Outer Dowsing Offshore Wind

5.1 Consultation Report

Annex 5.1.4B Section 42 Consultation Responses

Document Reference: 5.1.4B

Plate 13.13.1: Illustrated outline deposit model (Array Area). Adapted from Outer Dowsing Offshore Windfarm Geophysical UHRS And Light Geotechnical Survey East Anglia, Offshore UK, ENVIROS Survey & Consultancy Limited, 2022.

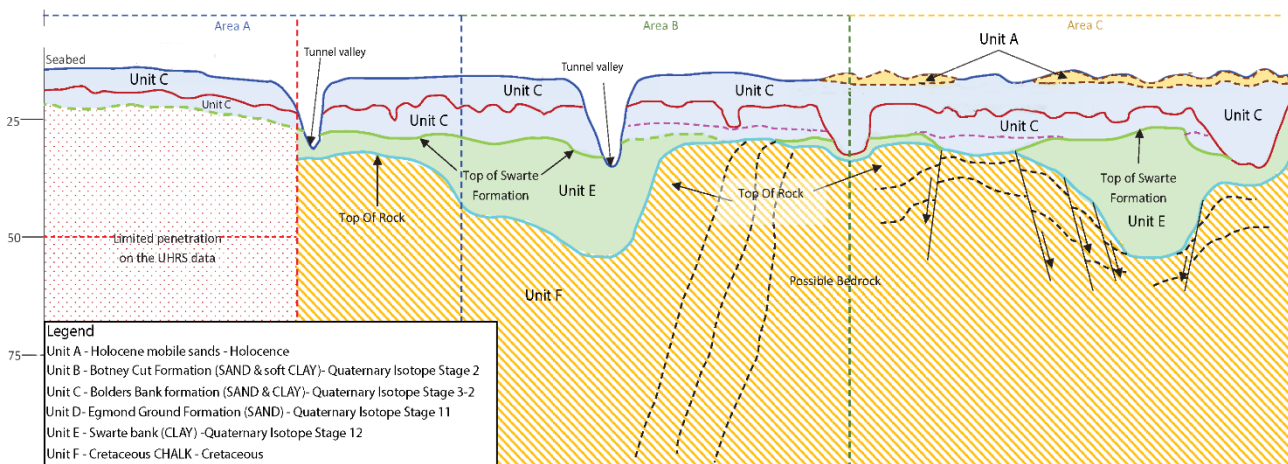
48	Historic England	P2_11	<p>Table 13.7 (Outline Deposit Model) - this is not a deposit model, it lists, alphabetically, geological units without any spatial relationship to the proposed development location. It is therefore not readily possible to relate this information to Figure 13.9 which utilises information derived from the North Sea Palaeolandscapes Project by V. Gaffney et al., (2007). It is also conspicuous that no attention is given to geotechnical ground-truthing as will be necessary to effectively guide this proposed project. In the absence of any information regarding palaeo-environmental potential in the ECC, we cannot offer any further comment or advice at this stage.</p> <p>We note subsequently in the same document that the ‘Deposit Model’ is provided (Volume 1, Chapter 13 - Marine and Intertidal Archaeology, Document No. 6.1.13) and it states:</p> <p>13.8.12 At this time there have been no offshore geotechnical surveys undertaken for archaeological assessment, however, these are planned post consent. Geoarchaeological sub-sampling will be included and informed by the results of the sub-bottom data analysis and previous geoarchaeological assessment of the area.</p> <p>Regardless of whether dedicated archaeological borehole surveys has yet been undertaken, the opportunity should have been taken to integrate archaeological assessment into any appropriate geotechnical work that was underway.</p>	This Applicant has noted this response.
